From: Abi Hudlass-Galley [REDACTED]
Sent: 03 June 2019 09:44
To: Planning
Subject: Fwd: P/38/19/PL - Urgent Objection Newlands Residents Group (25 objections)

The Residents surrounding Newey would like to place on record their joint objection for the application of a two months extension to retain caravans at the Newey Roundstone Nursery. At present, as you are now aware, there are no caravans, so using the word *retain* is somewhat dubious.

Site Location Plan
PROPOSED
Feb 2019
0119-001 B
1:2500@A3

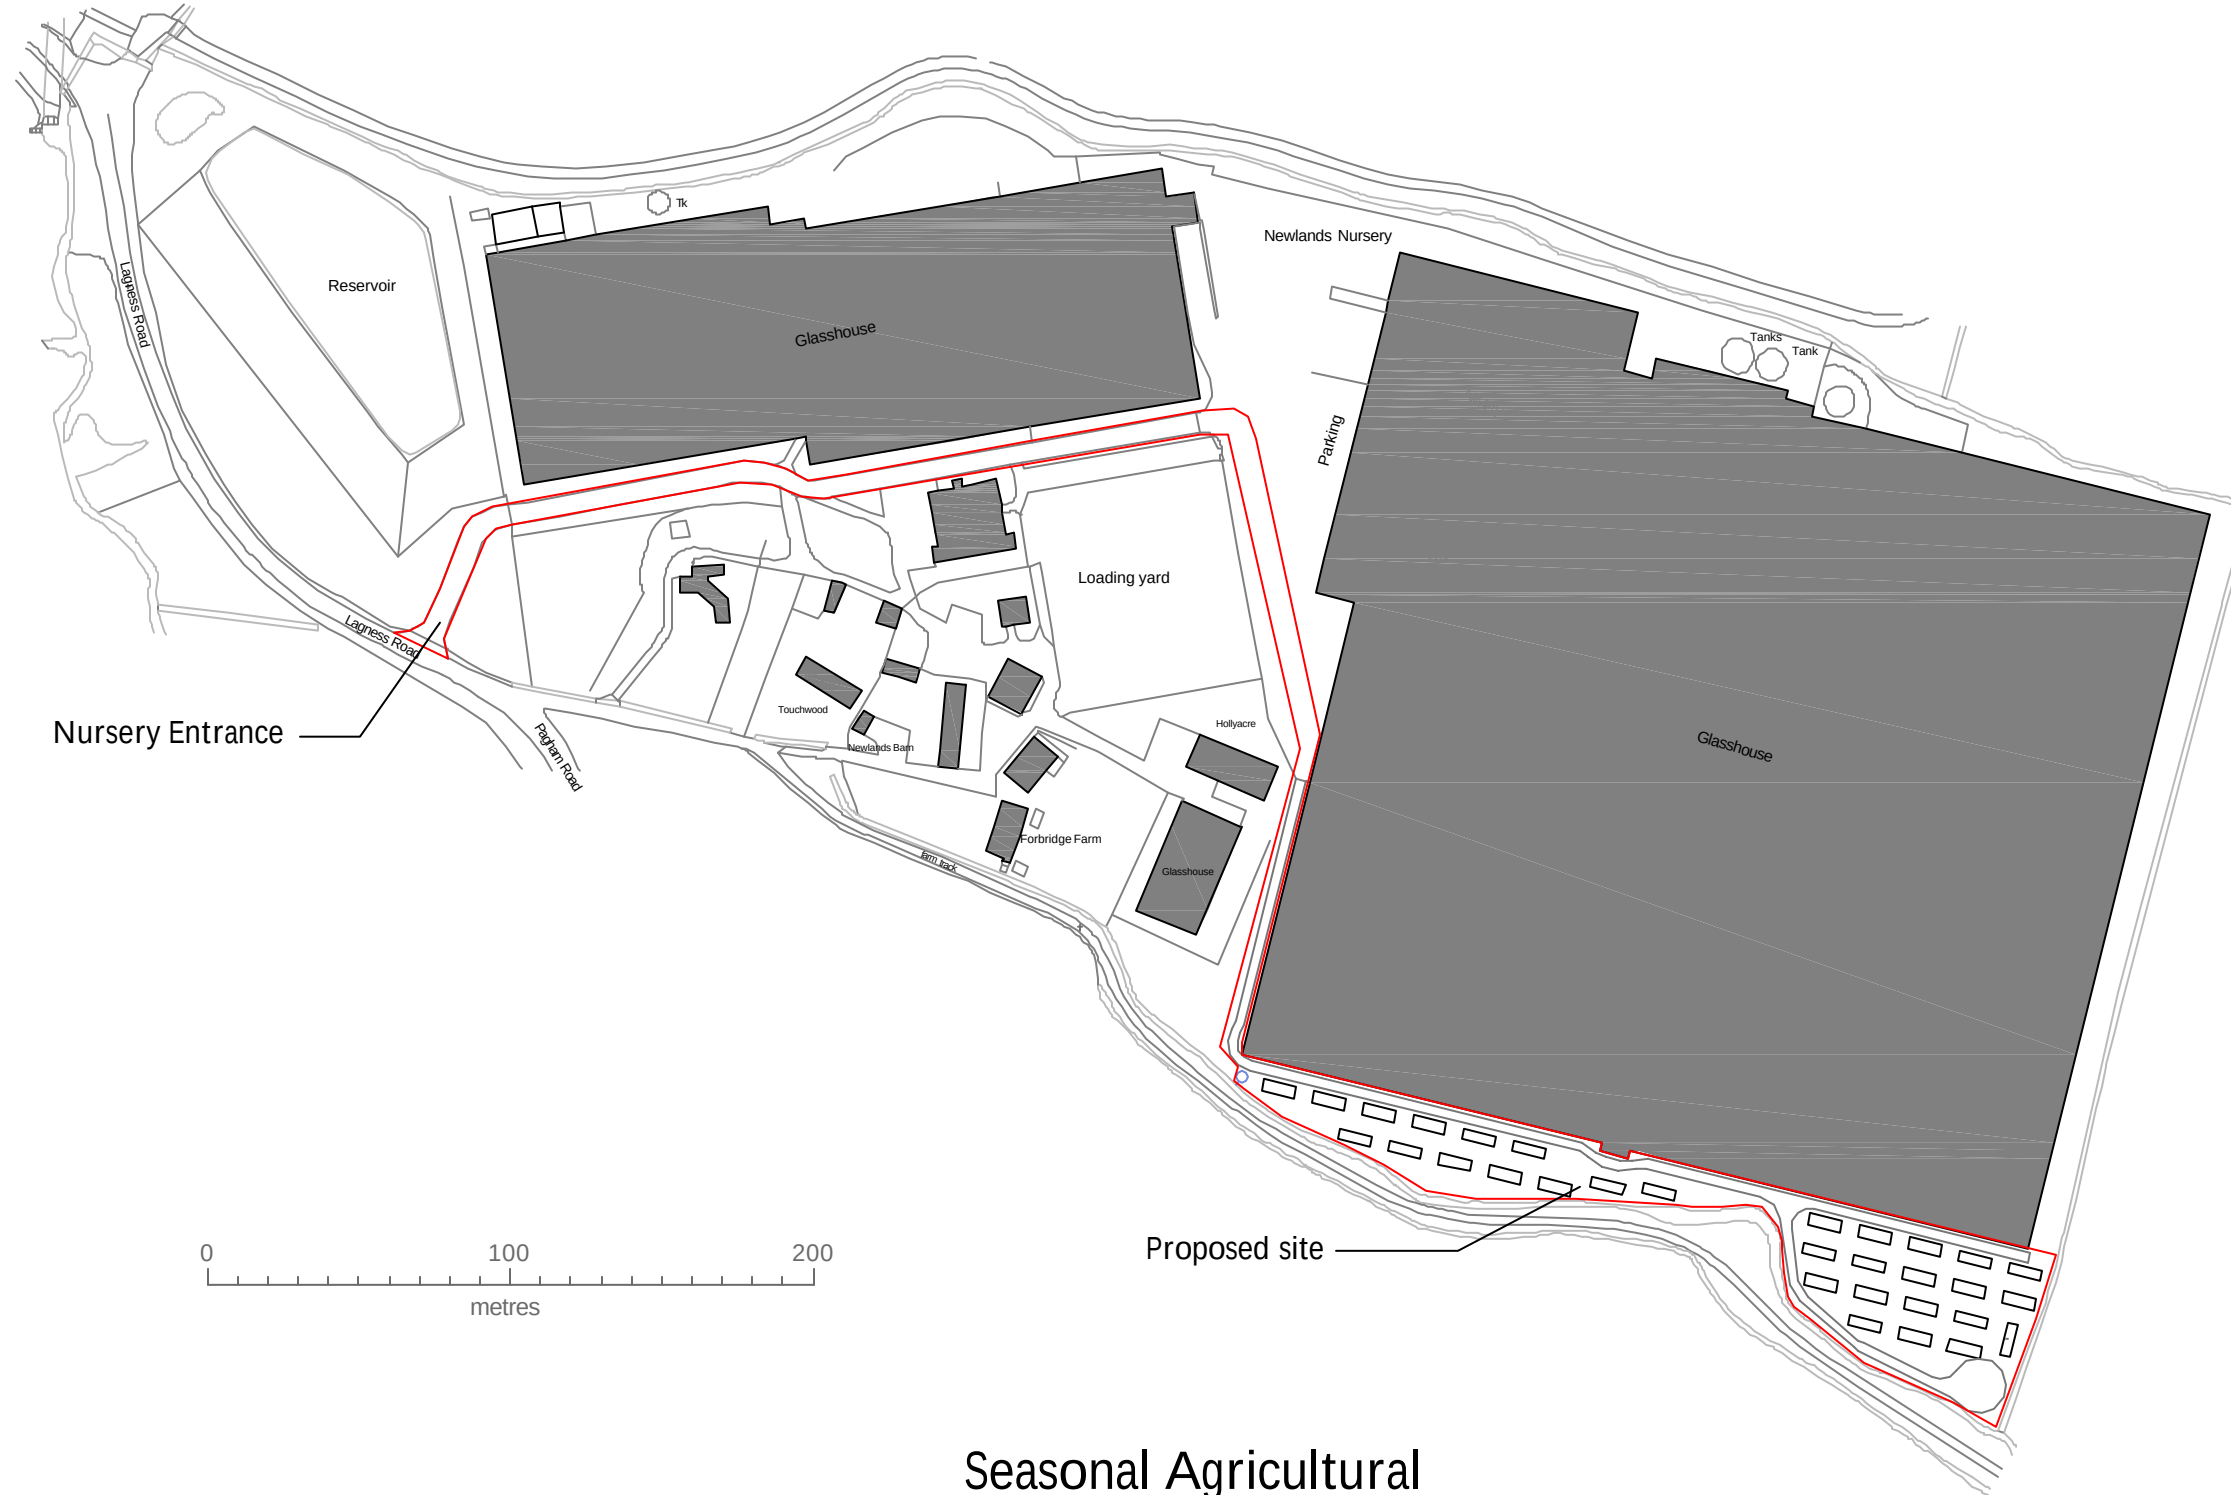
We notice from Google earth that other seasonal worker sites in the area do not have residents near them, so find it impossible to understand why this application was made. It is possible that the Douglas Briggs Partnership were not aware of us, as we certainly weren't mentioned in the application and the maps included made it look like most of our homes were part of the nursery, and the other two homes were just off the map so not shown at all. I understand you have already queried exactly what land they actually own.
